Report for BCA Compliance

PROJECT NAME: Sydney Opera House – Renewal Project – Front of House – Creative Learning  
Centre – For SSD Submission - Rev B1

DATE: 7 September 2018

1 GROUND FLOOR PLAN
1:100

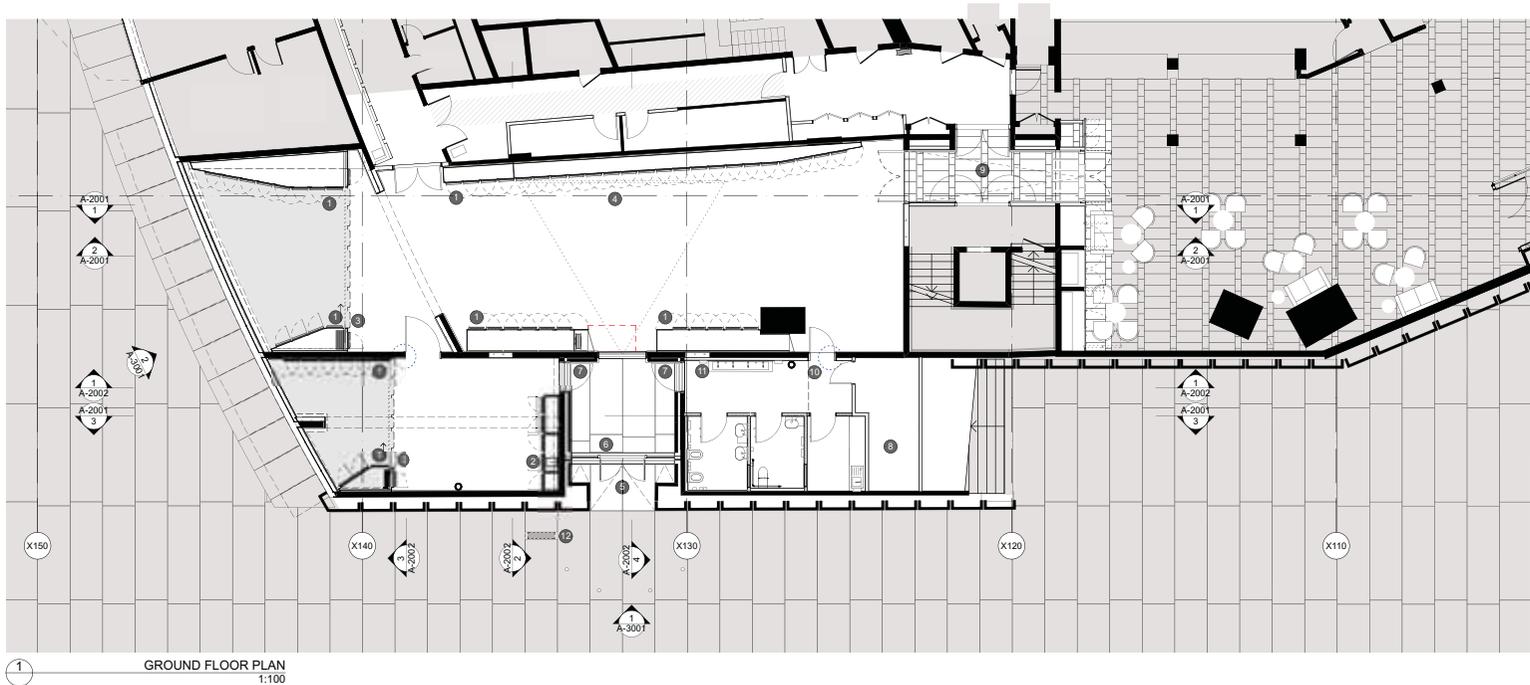
Item No.	Query or DTS Non- Compliance	Suggested Resolution	BCA Clause	BCA Performance Requirements
1	Entry Lobby 1 Door D/GR-05 and existing Entry Lobby door south, have been illustrated with a fire rating of -/60/30 in lieu of -/120/30 as required by the FRL plans.	Fire Safety Engineer has confirmed the feasibility of a Performance Solution, refer Section 10.4 of Front of House FER 243928-08 Rev C02 dated 24 November 2017.	C3.5	CP2, CP8
2	Inadequate fire hose reel coverage. Areas cut off by the fire compartmentation Design as follows: <ul style="list-style-type: none"> <li>Store 1 (G503)</li> <li>Store Rooms (G510-512)</li> </ul>	Fire Safety Engineer has confirmed the feasibility of a Performance Solution, refer Section 10.5 of Front of House FER 243928-08 Rev C02 dated 24 November 2017.	E1.4	EP1.1
3	Altered Fire Stair 17 Arrangement: <ul style="list-style-type: none"> <li>Internal fire stair discharge in lieu of direct to open space.</li> <li>Lift and stair within the same shaft.</li> <li>Cupboards within the stair.</li> </ul>	Fire Safety Engineer has confirmed the feasibility of a Performance Solution, refer Section 10.3 of Front of House FER 243928-08 Rev C02 dated 24 November 2017.	D1.7, C2.11, D2.7	CP2, DP2, DP4, DP5 EP2.2

4	Closed out.	-	-	-
5	CLC – A 1:40 landing is required to the new entry door GR-18, in lieu of the currently illustrated/proposed 1:10 & 1:13.	Access Consultant to confirm the feasibility of a Performance Solution.	D3.1, Premises Standard,	DP1, DP2
